**District:** Cherwell

**Application No:** 20/03630/DISC

**Proposal:** Discharge of Condition 12 (landscaping scheme), 20 (Landscape and Ecology Management Plan (LEMP)), 21 (external lighting) and 22 (electrical vehicle charging) of 19/01740/HYBRID

**Location:** Land Adj To Promised Land Farm, Wendlebury Road, Chesterton

Drawing Number:
41602(62)101

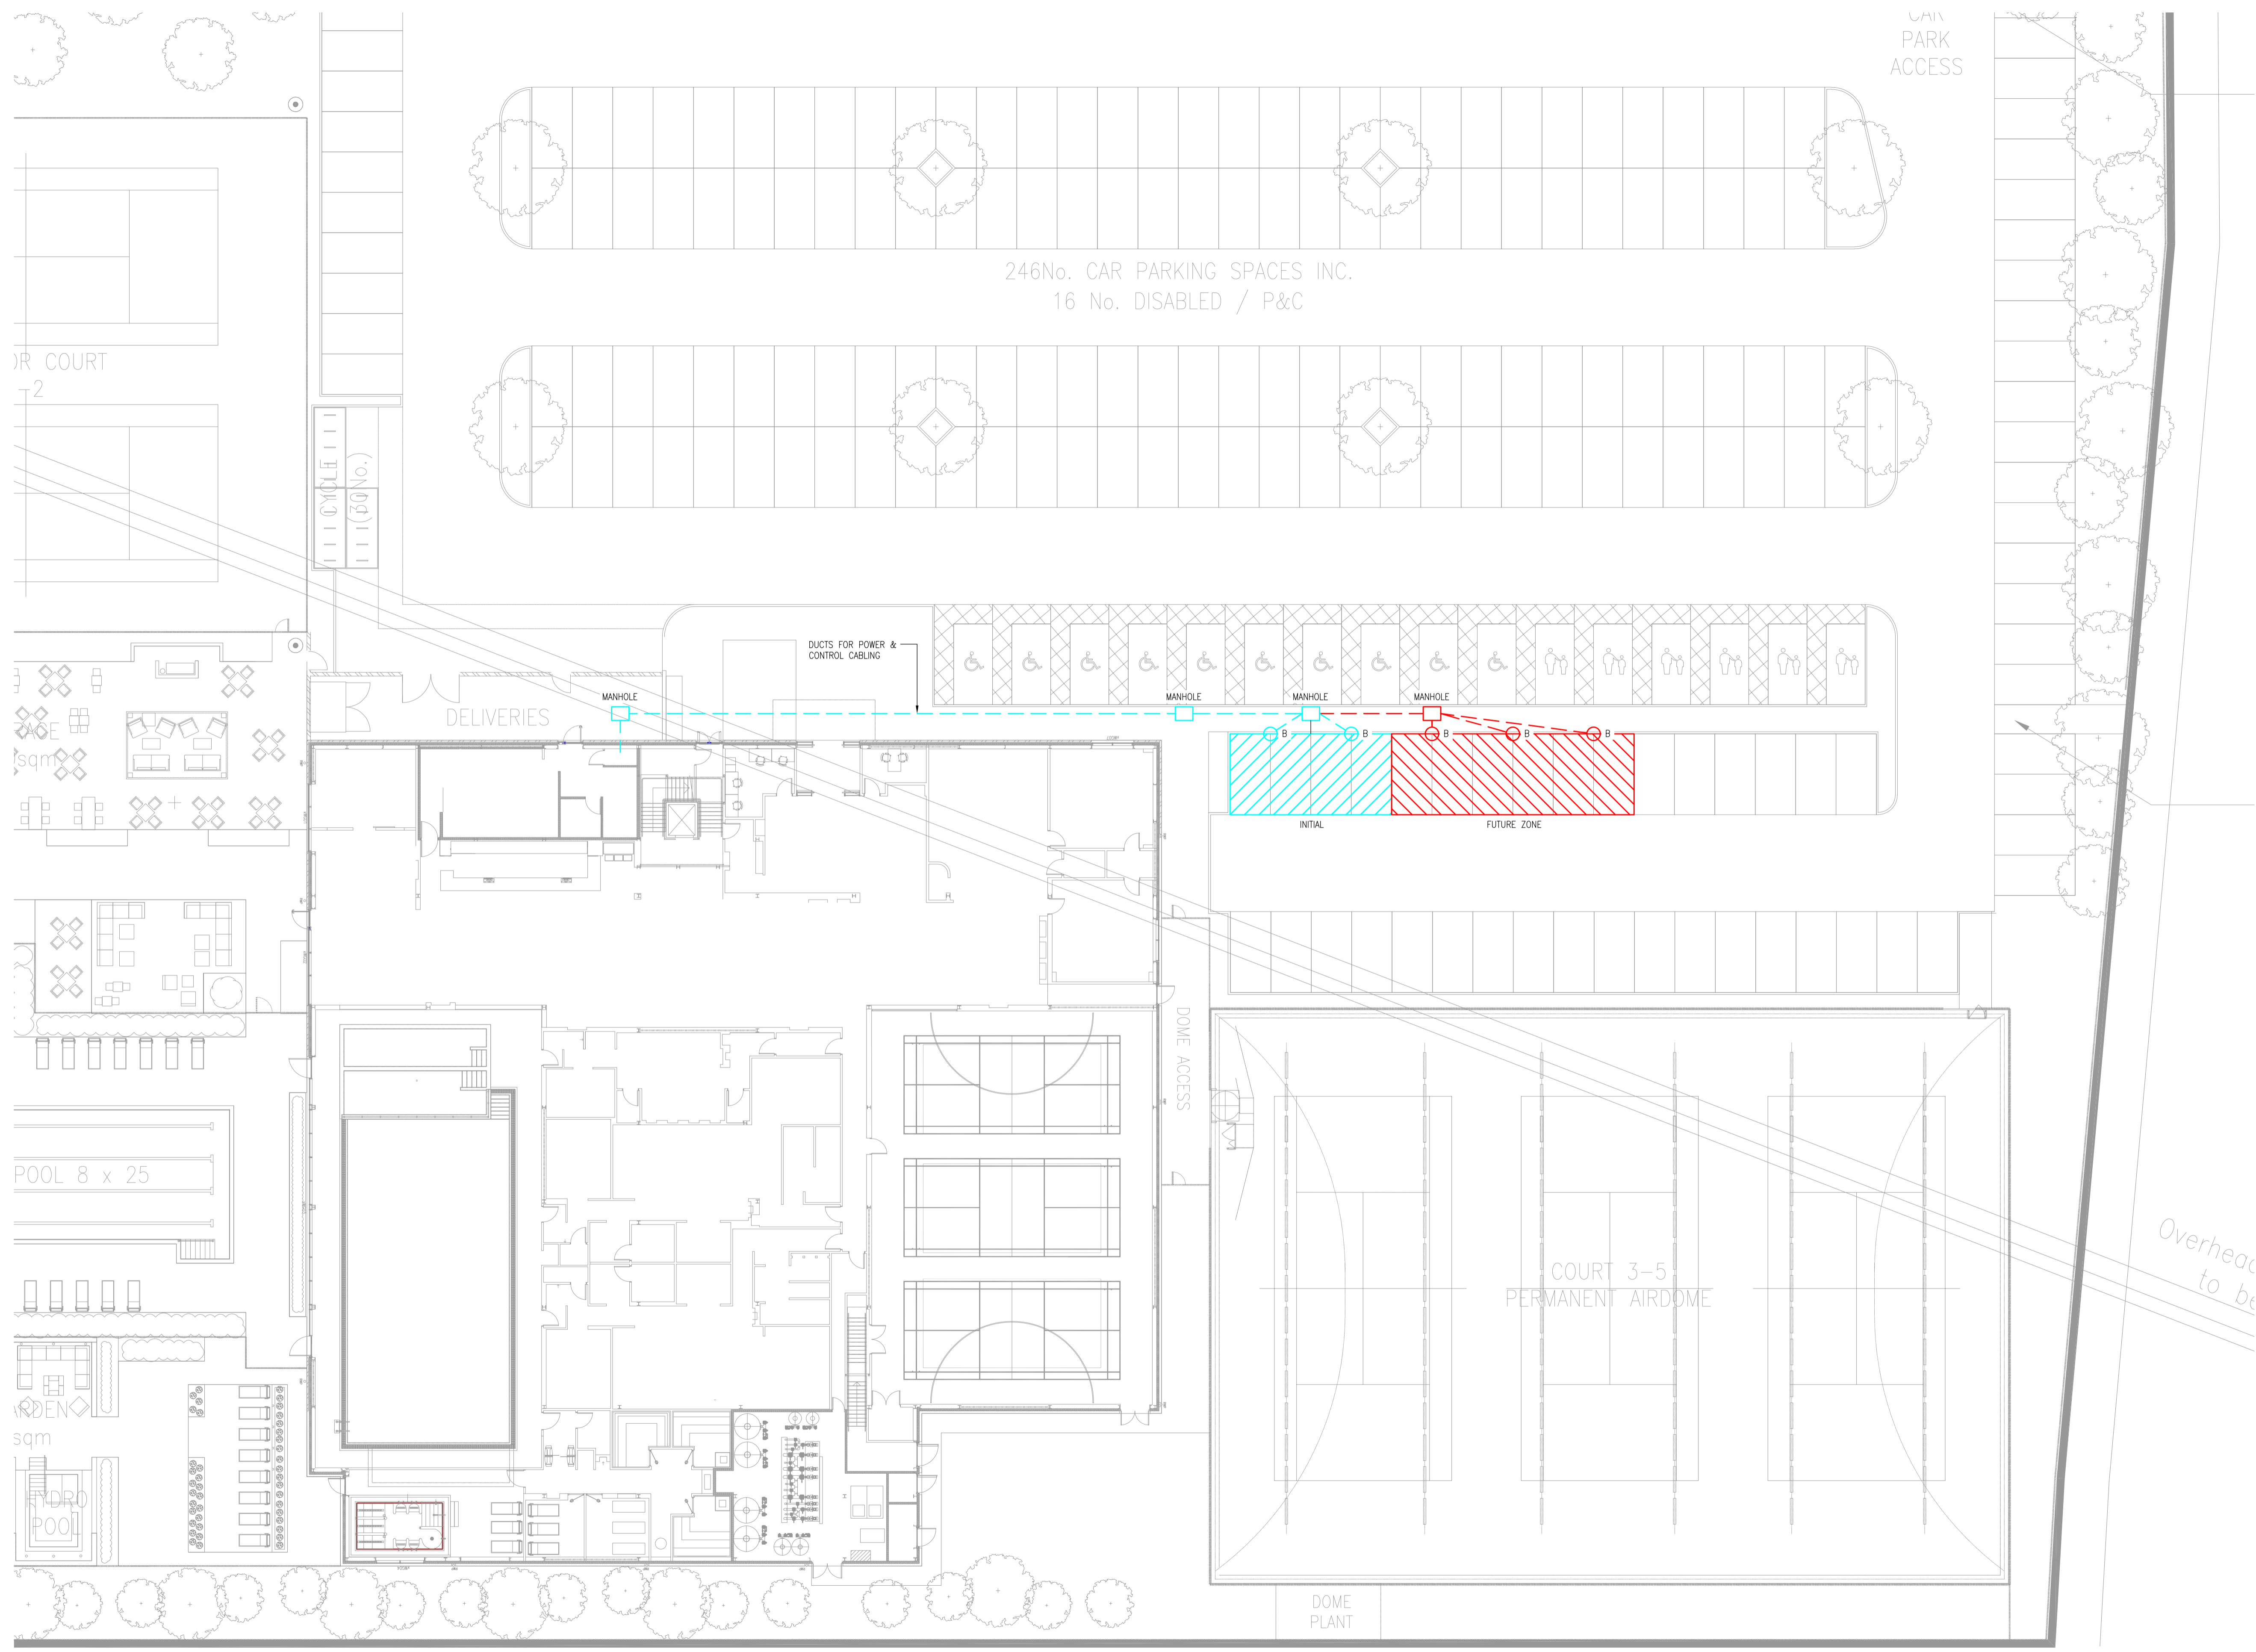
This is a revised submission following our objection to the previous one, where the level of provision of electrical car charging units and ducting for future expansion was deemed inadequate to meet the requirements of the condition.

Drawing No: 41602(62)101 Rev P1 and the Car Charging Report (dated February 2021) now show an increased level of provision of both the EV charging spaces and also spaces ducted for future electrification when the demand arises. The revised detail is acceptable and I wish to withdraw the previous objection.
